3 December 2018

P0925 CMCC Response to Submissions

Re: Response to Submissions Catherine McAuley Catholic College

This document has been prepared as part of the Response to Submissions for the Catherine McAuley Catholic College development (SSD 8989) for the issues relating to traffic, parking and access. This includes responses to:

Figure 17 | Vehicular access (source: RtS 2019)

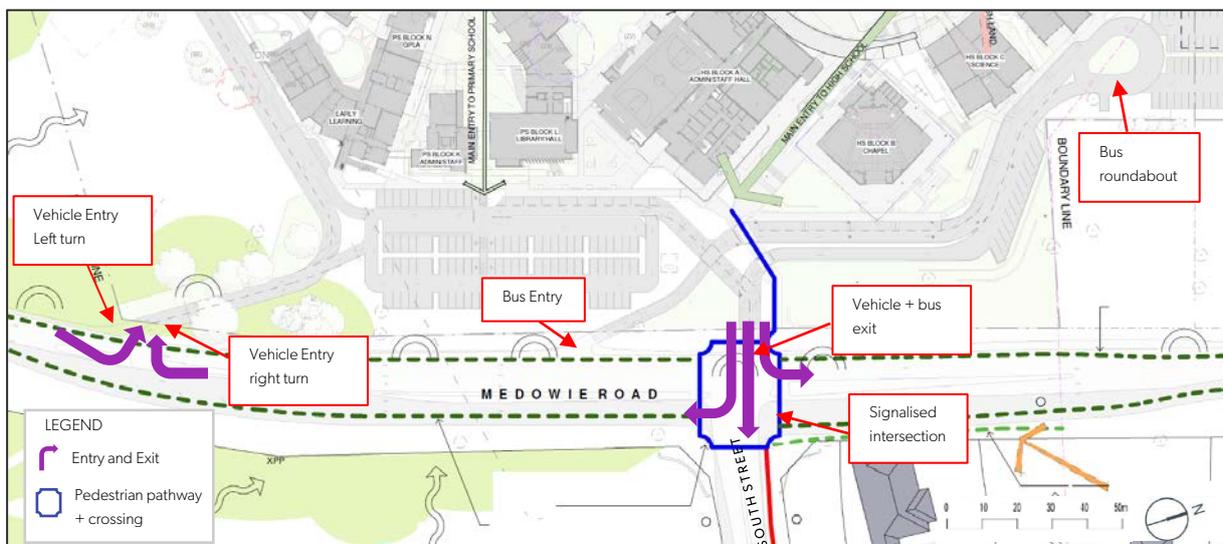
<p>a. The proposed right-turn into the school, across the northbound travel lane, will pose increased safety risk for potentially inexperienced drivers (school students). The proposed location is on a high volume and high speed section of road. This turn would be much better accommodated within the proposed traffic signals, especially as a high proportion of trips will originate from the Medowie direction;</p>	<p>The right turn into the site to the south of the new signals has been discussed and supported in principle by the RMS. During the critical high traffic demand periods i.e. drop off and pick up there will be a 40 km/h speed zone in operation, with much lower demands outside of this period. Visibility at this location is good and there are no specific safety concerns raised for this movement. This right turn has been designed in accordance with Austroads Guidelines.</p>
<p>b. The additional travel distance required for buses (from the Medowie direction) to enter the school and the increased safety risk of u-turning at the Richardson Road roundabout is not supported. The length of road between South Street and including the roundabout has a significant crash history. Council has received written and verbal advice from bus operators voicing concerns regarding the proposed bus access arrangements;</p>	<p>The U turn for buses at the roundabout is not considered a safety risk, as accident rates for buses are typically much lower than light vehicles due to their high visibility and lower vehicle speed.</p> <p>During discussion with the bus company it was noted that in the PM it was likely the vast majority of buses would approach from the south, thereby not requiring the U-turn. In the AM it is anticipated approximately 12 of the total 29 buses would approach from the north, with no specific safety concern regarding these buses completing a U-turn manoeuvre.</p>

Requirement	Response
<p>Clarification of bus entry arrangements</p> <p>Comment:</p> <p>It is unclear from the road design plans whether buses heading south along Medowie Road would be able to utilise the bus entry access via a right-in movement.</p> <p>It is preferred that a right-in movement is made available as an alternate route. Using a left-in only access would increase the time and cost to operate bus services to the school.</p> <p>Recommendation:</p> <p>The Applicant should confirm whether buses heading south along Medowie Road would be able to utilise the bus entry access via a right-in movement.</p>	<p>The right-in bus movement at the traffic signals was not included due to the high number of bus movements anticipated for the development, with requirement for buses to queue on site.</p> <p>The options analysis (completed by Webber Architects) identifies the constraints for the internal road network in this regard, with the final layout of the internal road network not having sufficient area for buses turning right into the site to queue, with the potential risk of queuing back onto Medowie Road unacceptable.</p>

Figure 18 | Road design plan (source: RtS 2019)

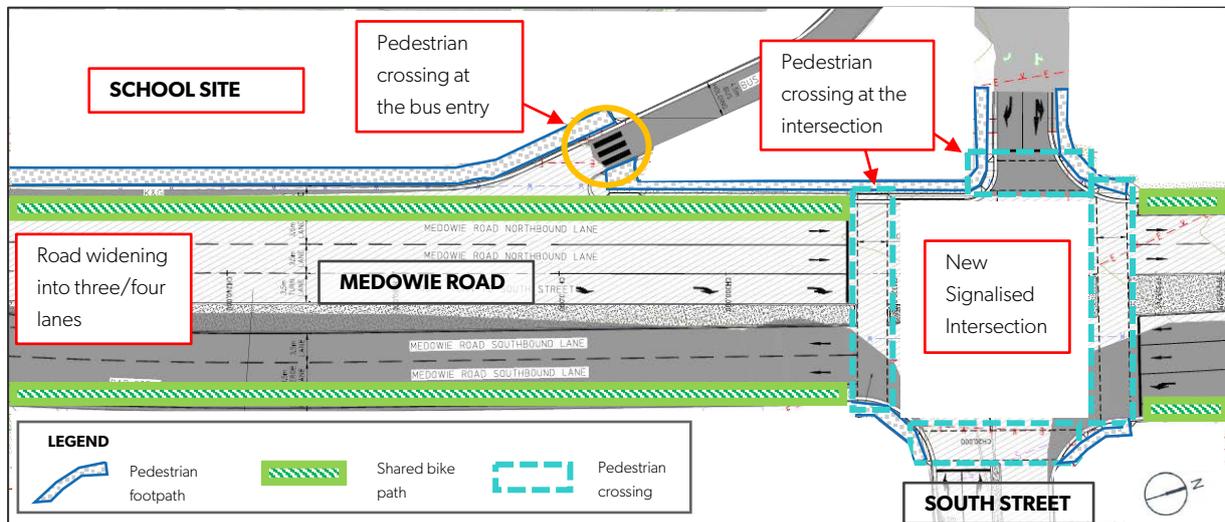
Requirement	Response
<p>There appears to be little provision for pedestrian access to the campus, with no footpaths shown on the proposed Medowie Rd / South St intersection upgrade.</p>	<p>Pedestrian access provides connection to the traffic signals which incorporate pedestrian phasing.</p>
<p>The extent and configuration of car parking has a significant impact on the proposal, particularly in terms of pedestrian amenity / safety and campus identity / presentation. This has been a key issue since the preliminary review sessions with GANSW. While some improvements were made during the review period – between meetings one and two, this issue has not yet been adequately addressed.</p>	<p>Parking provision exceeds the DCP but has been determined based on other schools and ensures that all parking can be accommodated on site. RMS indicated that no parking will be permitted on Medowie Road and development must ensure adequate off-street parking.</p>

Figure 19 | Car parking layout and bike parking spaces map (source: RtS 2019)

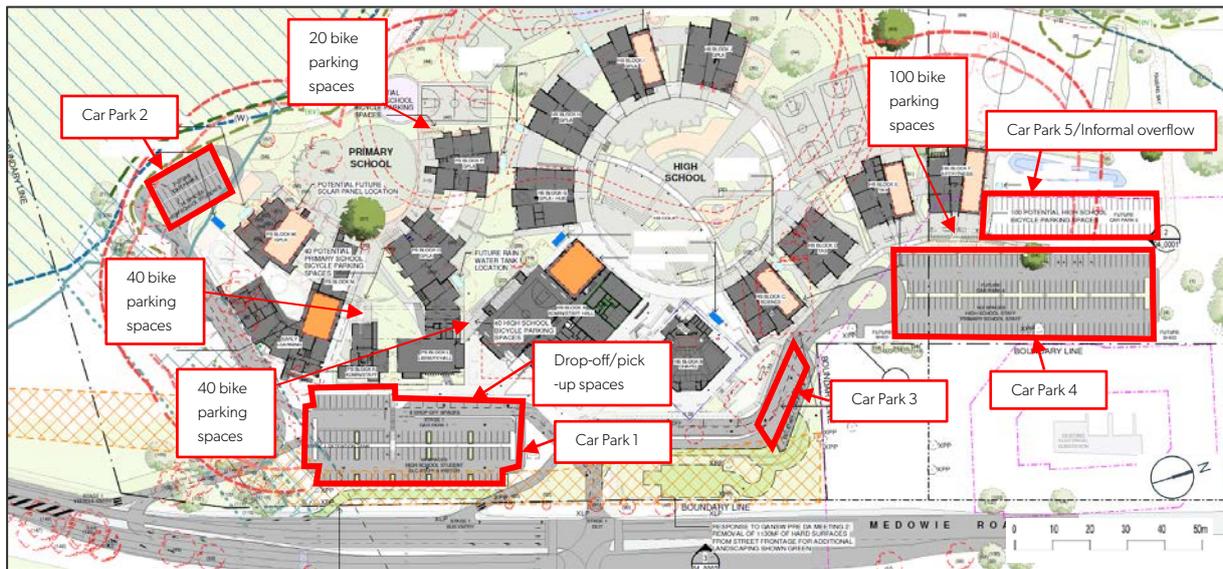
<p>Provisions for car parking seem excessive. There are 272 formal spaces (44 more than required by the Port Stephens DCP) with an additional 50 informal spaces as well as 12 on site bus bays which will be used for car parking outside key bus drop off/ pick up times. The combined impact of these, together with a complex internal road system, creates an extensive asphalt terrain that dominates the campus frontage.</p>	<p>Parking to cater for school visitors and mid-week demands for the chapel was provided, which is not incorporated under the DCP rates.</p>
<p>Bicycle parking has been provided but it is located at the far end of the secondary campus. While this is practical in terms of proximity to change rooms (which can double as end of trip facilities) it should be more centrally located to promote bicycle use by staff and primary students.</p>	<p>Bicycle use is considered to be required for the senior school primarily with minimal use by the junior school.</p>

<p>Bicycle parking and end-of-trip facilities</p> <p>Comment:</p> <p>The Traffic Impact Assessment states that “bicycle storage facilities will be provided within the school grounds to cater for both staff and student cycling demands”. However, no indication has been provided as to the quantity of storage spaces that would be provided as part of the proposal. The report identifies that the DCP requires that the proposal should provide a total of 198 spaces, however, recommends a provision of 148 spaces would be appropriate.</p> <p>Recommendation:</p> <ol style="list-style-type: none"> 1) The Applicant should state the quantity of bicycle parking spaces proposed to be included as part of the application. Any bicycle parking should be supported with end-of-trip facilities that are located in secure, convenient and accessible areas in accordance with relevant development control plans and guidelines. 2) DP&E should include a condition of consent requiring a provision of 148 bicycle storage spaces, which would be located and designed in accordance with AS2890.3, and supporting end-of-trip facilities. 	<p>The recommended rate in the Council DCP (198 spaces) is not appropriate for this site, given only 5% of each schools population are anticipated to walk/cycle (being less than 100 students in total).</p> <p>The TIA states “A reduction to 50 bike spaces is therefore proposed for the site”.</p> <p>This refers to a total of 50 bike spaces being appropriate, not a reduction of 50 off the 198 to give 148 as stated in the TfNSW commentary which would equate to more bike parking than the total students within a reasonable walking/cycling distance.</p>
